November 30, 2023

Re: Project File No.: Cu-23-00002
Project Name: The Outpost
Applicant: Michael Jackson (Landowner); Shari Bay (Authorized Agent)

We represent interested and adversely impacted landowners and provide these comments with regard to the *Conditional Use Permit Application* proposing development of a campground and guest ranch at 13131 Salmon La Sac Road, Ronald, WA 98940. These comments address several key issues that warrant careful consideration before approval can be granted. We reserve the right to provide additional comments on both the land use application and environmental review and determinations.

**CONCEPTUAL SITE PLAN
MULTIPLE PARCELS**

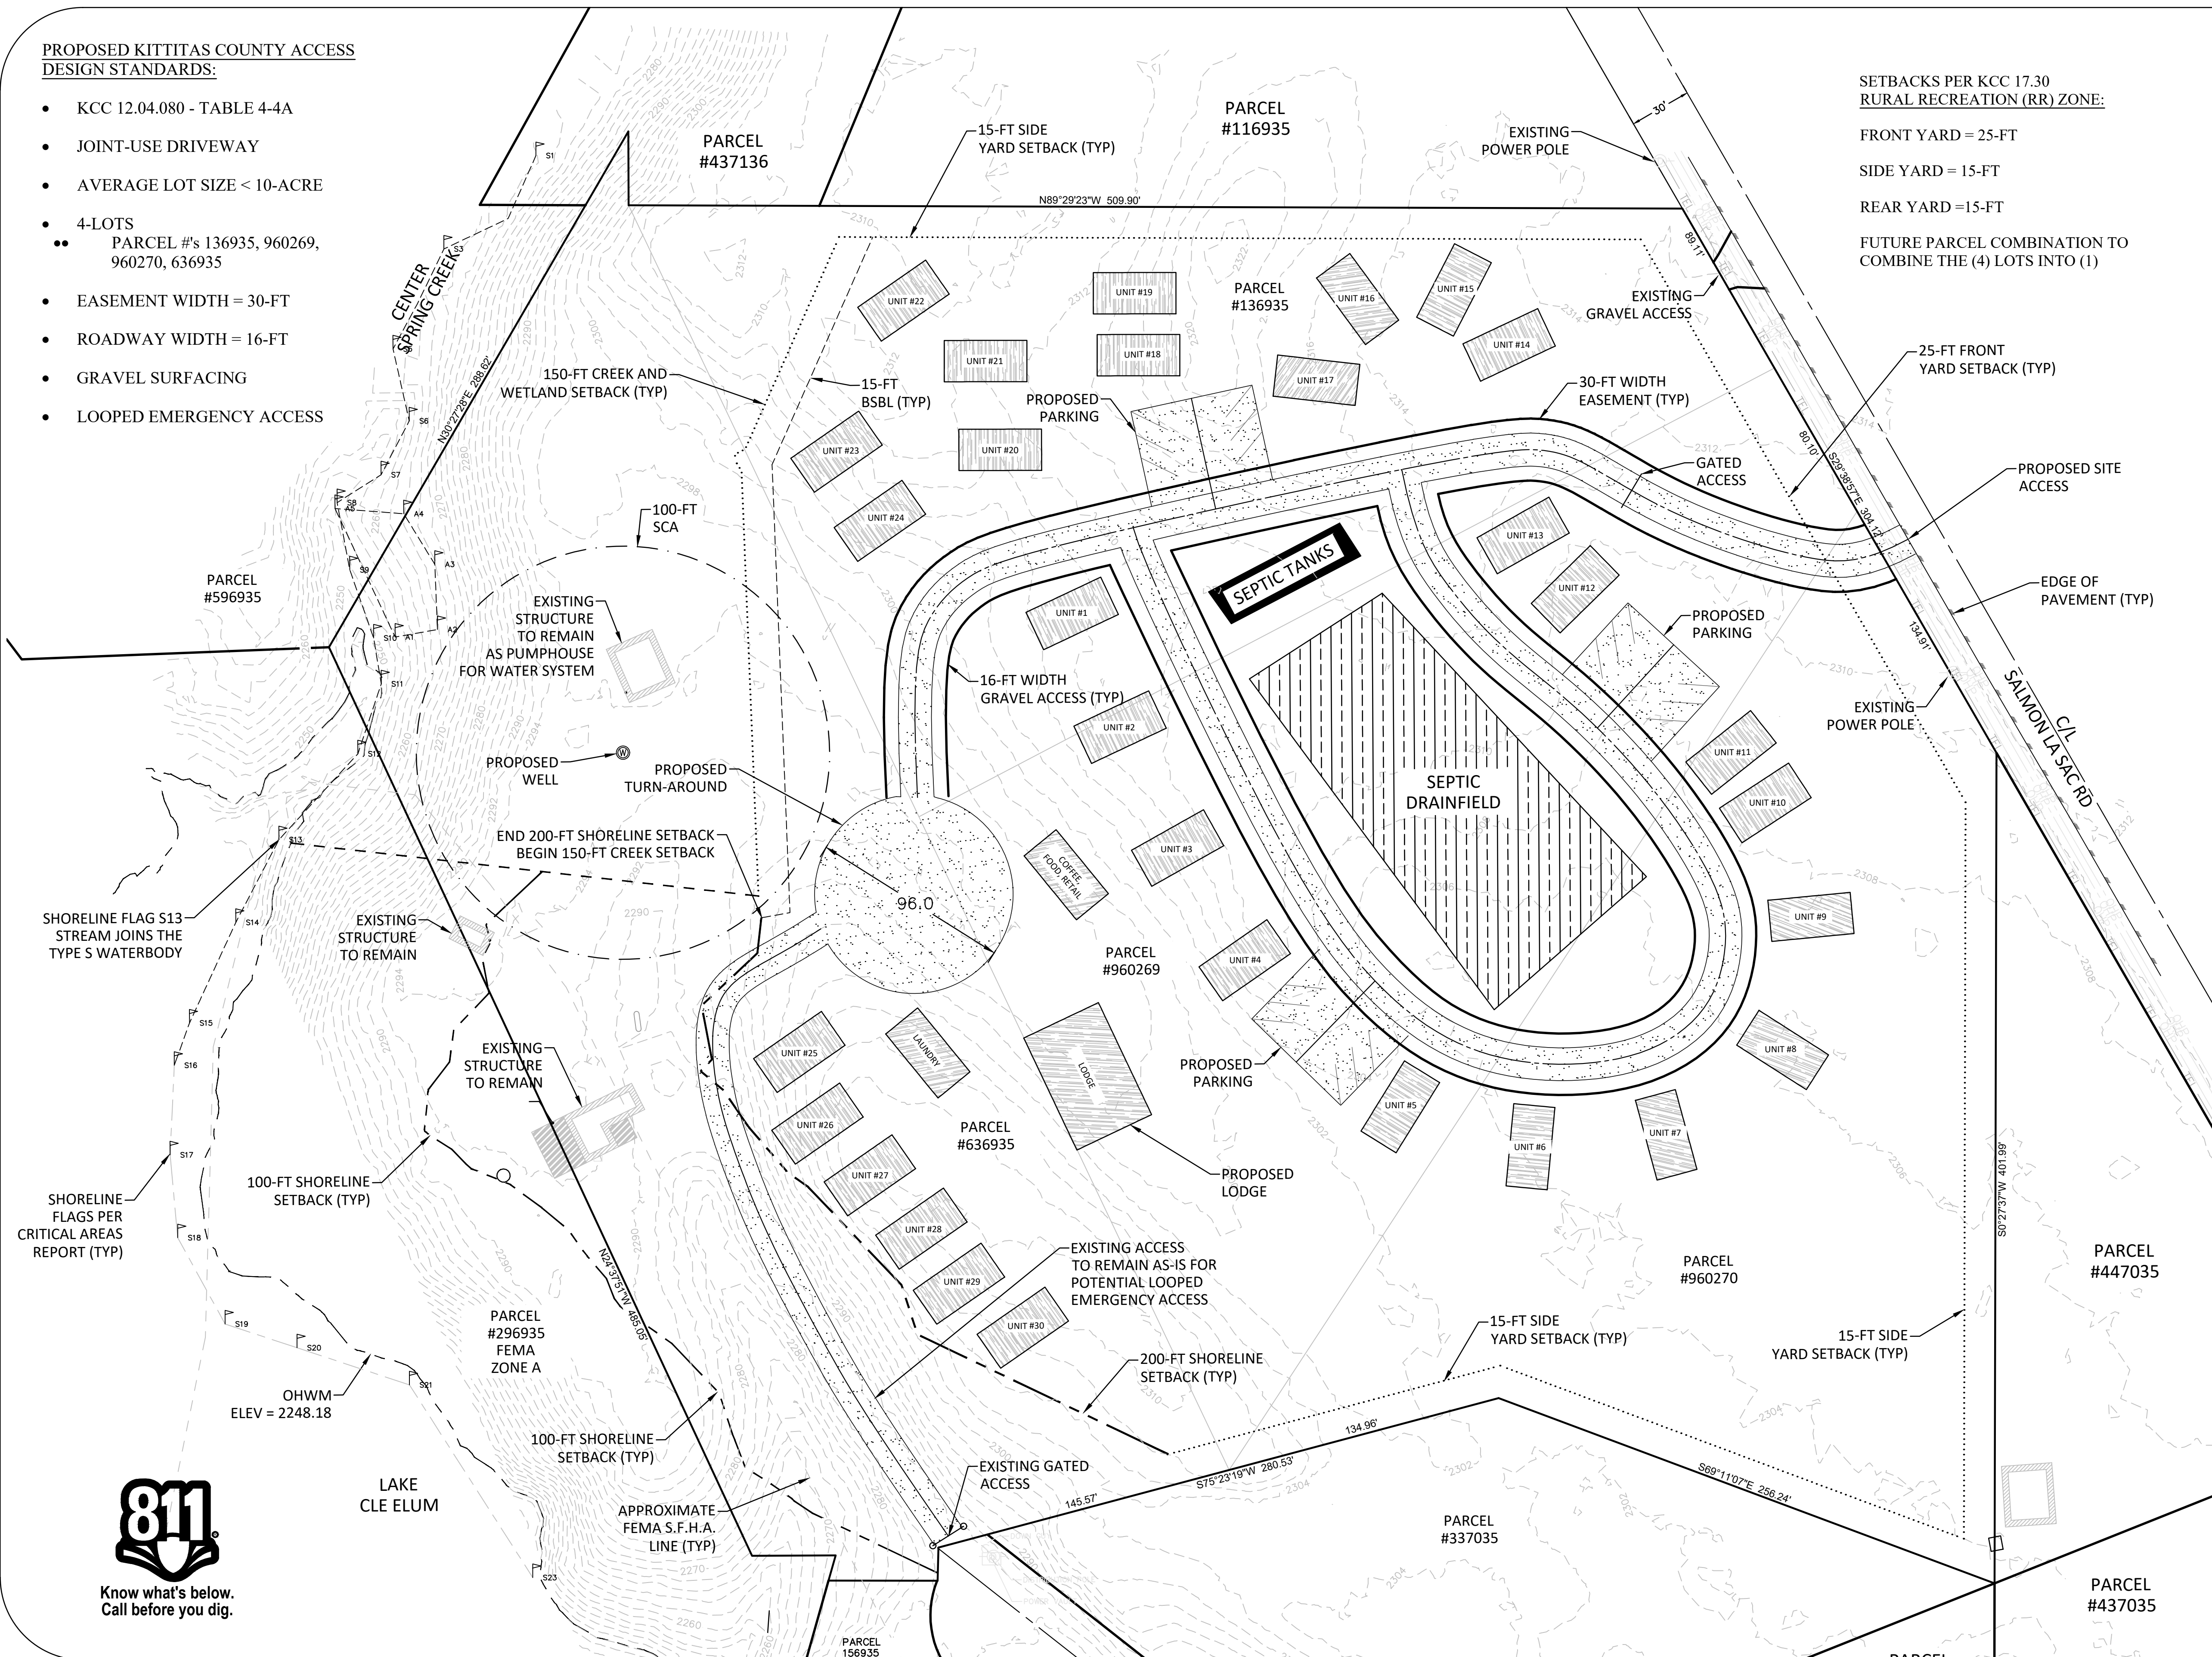
- A. Applicant proposes a driveway on 30' easement with 16' gravel roadway width. The proposed driveway violates KCC 12.04.070 Table 4-4A (See Exhibit A) standards. A Joint Use Driveway standard may be utilized only when serving four or fewer units. Applicant proposes a substandard driveway to serve thirty (30) units.

- B. The proposed 30 units requires a 60-foot minimum easement, paved aprons for each unit, and a 22-foot roadway with 1-foot shoulders, none of which are addressed in the submitted site plan. KCC 12.04.080 – Table 4-4A.

- C. The access is also contrary to International Fire Code (IFC) standards for fire apparatus access roads set forth in IFC Appendix D.
- D. The failure to meet these requirements poses a serious fire, life, and safety concern, warranting the withdrawal and reissuance of the application once compliance with county code is achieved in its design as shown by a revised site plan for further comment.
